From: Paul Cann
Sent: 07 February 2018 10:35
To: Planning.Responses
Cc: Richard Temple; [REDACTED]
Subject: RE: Planning Consultation on EG/3/18/DOC

APPLICATION **EG/3/18/DOC**

Site Address: 15 Highview Road Eastergate PO20 3XB

Description of Works: Approval of details reserved by condition imposed under
EG/58/17/HH relating to condition No. 4 (Surface water
drainage)

© This drawing is the copyright of Robert Clark Associates Limited It may not be copied or reproduced without their written authority			
Scale	As shown	At original	A3
Drawing Number	1758/D1.1		Revision -

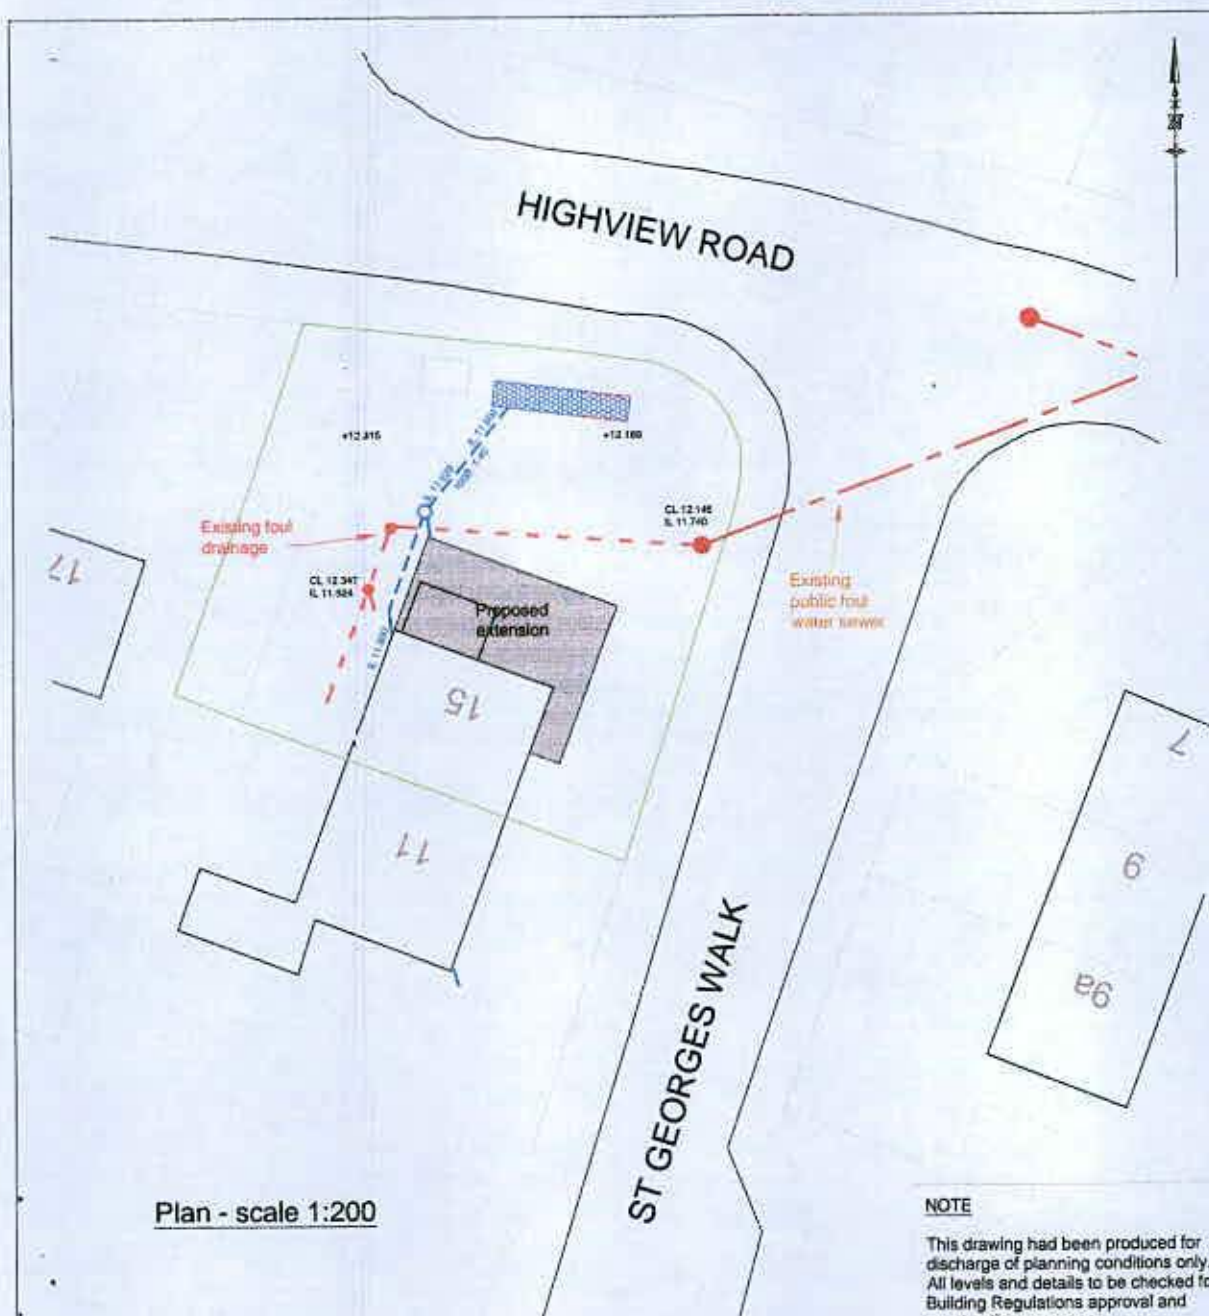
1. For clarity, on the layout drawing, please specify the base level of the crates and top of crate level.
2. Again for clarity, show dimensions for the length and width of the soakaway.

Some numbers on the drainage layout drawing are difficult to read, due to the scanning process, so I need to see a copy of the original drawing before I can comment further.
